Addendum to Flooding Assessment

MP06_0034

Preferred Project Report

Proposed Tourist and Commercial Development Goodnight Island and Greenwell Point

Figure 12: Proposed Development at No 84 Greenwell Point Road
(Source: Studio Internationale dated 22/07/09)

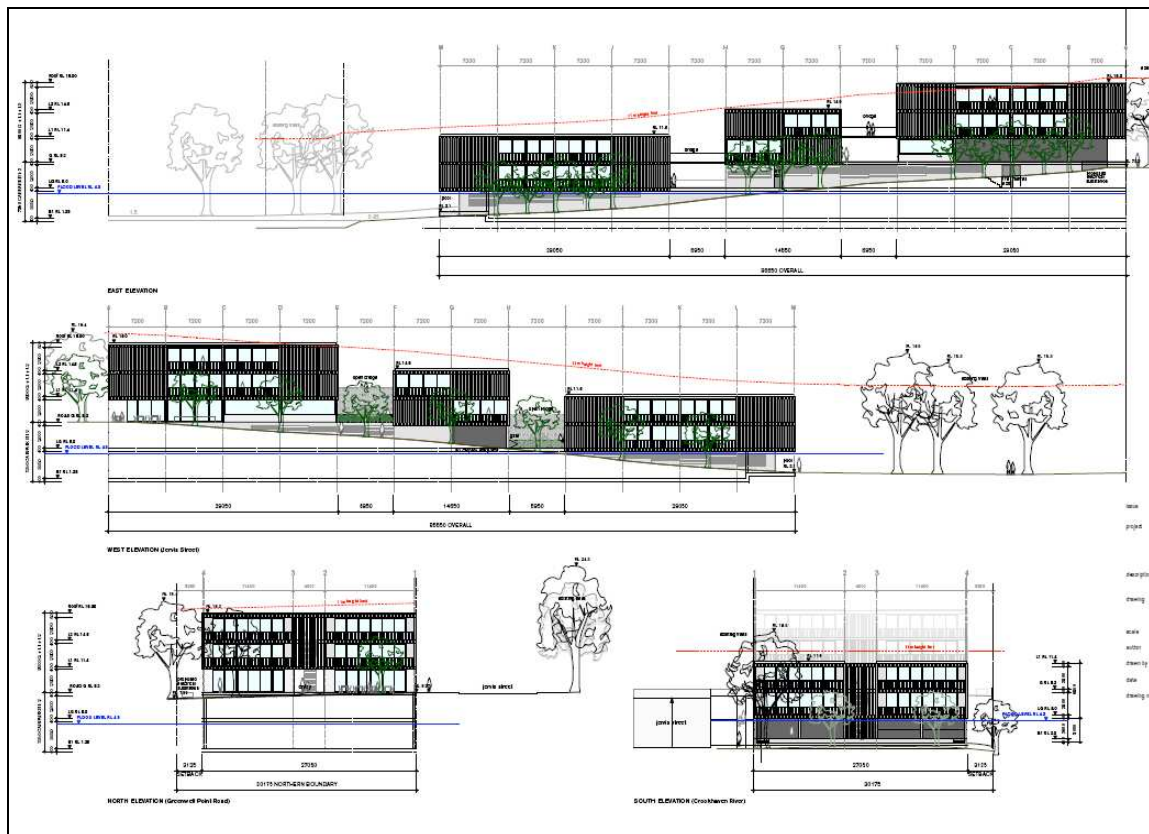
- 2. The existing house at 84 Greenwell Point Rd must have its habitable floor at or above the FPL.*
- 3. All basement car parks must be protected from inundation until at least the FPL and preferably to a higher level with an alternative access available should inundation occur.*

- 4. The proposed earthen bund at 84 Greenwell Point is an unacceptable form of flood protection as it can be relatively easily modified or eroded.*
- 5. The use of flood proof doors at 76 Greenwell Point Rd is not failsafe. For a new development the risk of inundation must be 'designed out' and not rely upon implementation of measures during an actual flood.*

Previous FPL was 3.7 mAHD. This has been increased by 600mm to 4.3 mAHD to account for sea level rise. New plans have been prepared which show all entrances to basement carparks are protected from inundation up to the FPL. Refer to the revised plans (plan numbers 2006-01 | MP05C-MP07C and 2006-01 | MP13C) provided by the projects architects.

Earthen bund has been removed from the development proposal as it is no longer required as a form of flood protection.

Flood proof doors have been removed from the proposal as they are no longer required as a form of flood protection. All basement carpark entrances are above the FPL of 4.3 mAHD.

Figure 13: Proposed Development at No 76 & 84 Greenwell Point Road
(Source: Studio Internationale dated 22/07/09)

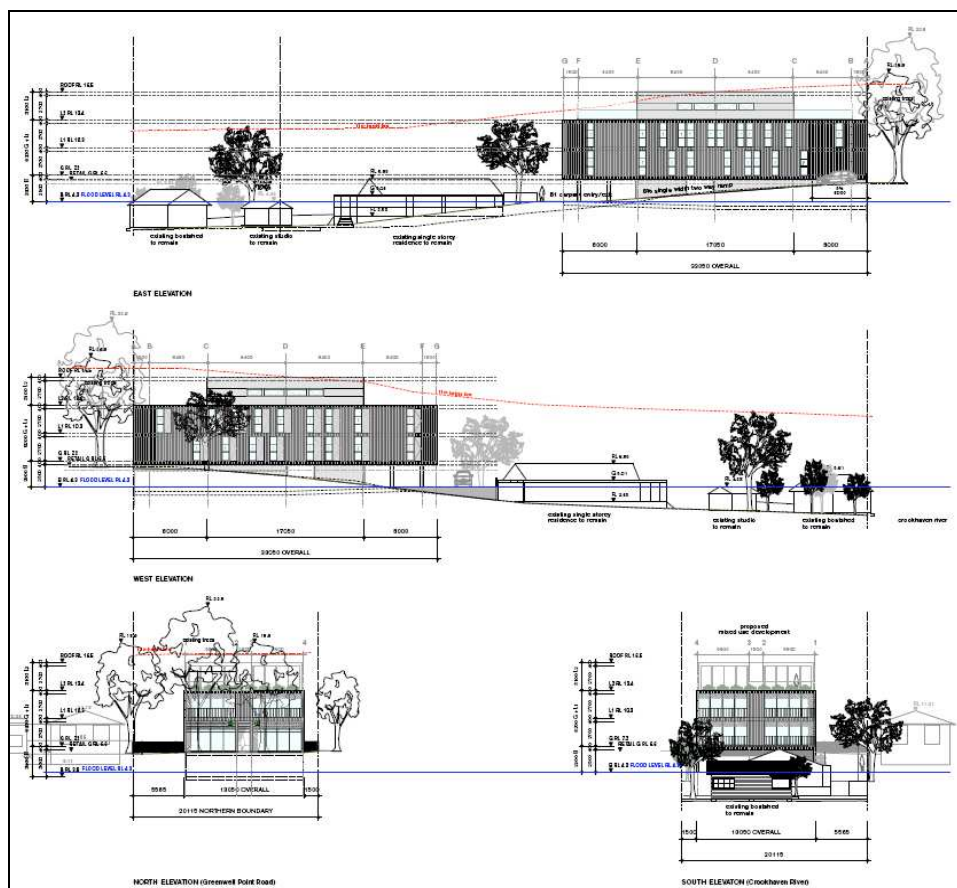
10. The proponent needs to provide further details regarding the definition of high hazard flood areas and the appropriateness of the proposed development in flood liable areas.

Figure 2 shows low and high hazard areas with respect to the proposed development and existing site conditions. We note that all building entry points are above the FPL.

New plans are provided (plan numbers 2006-01 | MP05C-MP07C and 2006-01 | MP13C) that comply with the FPL which has been raised by 600mm to account for climate change.
